Our Ref: BR/278/17/TC
Your Ref:

Town & Country Planning Act 1990 (as amended) s211 Notice
Application for Prior Notification of Work to Tree(s) in a Conservation Area

Development Remove deadwood to 1 No. Pittosporum tree, reduce height of 1 No. Bay tree by 3.5m & coppice 1 No. Bay tree within the Upper Bognor Road & Mead Lane Conservation Area.

Location Gerard Lodge 26 Upper Bognor Road Bognor Road

7. Identification Of Tree(s) And Description Of Works

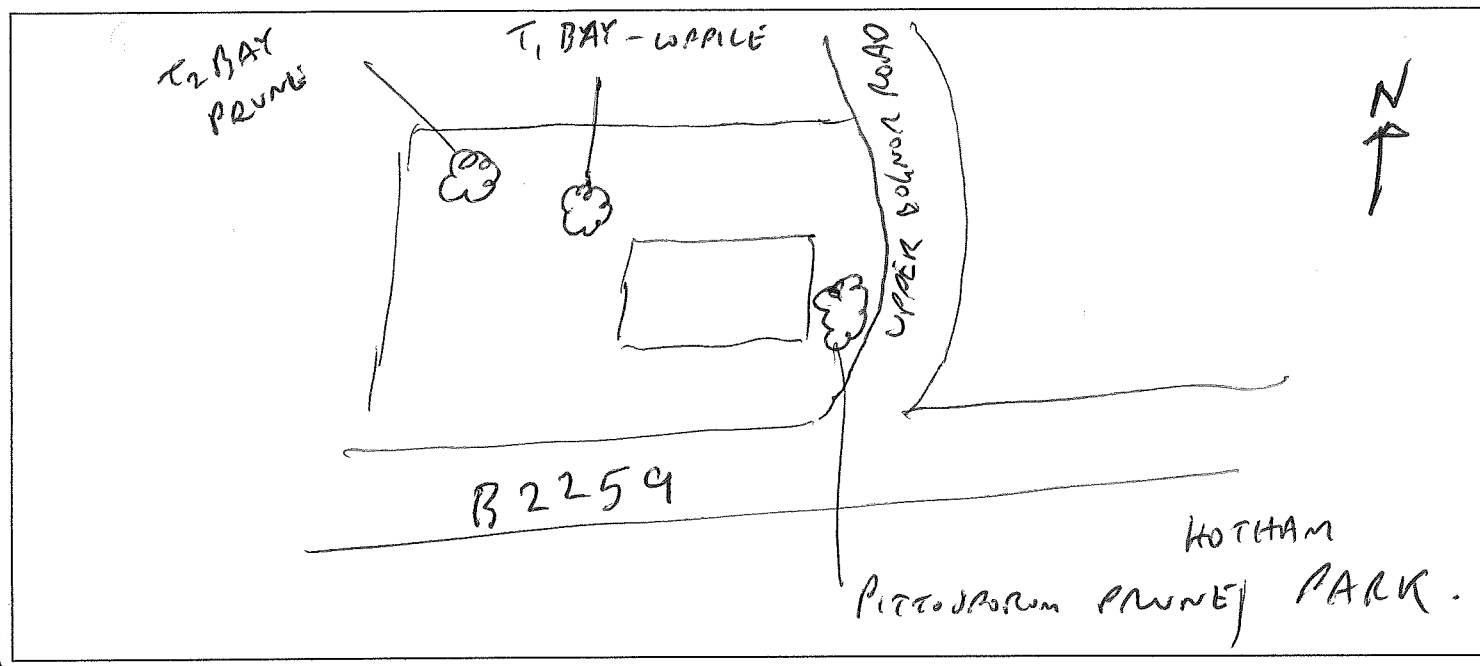
Concerning Bay tree T1, please provide the measurements for the coppice in metres or confirm you are pollarding to previous pruning points.
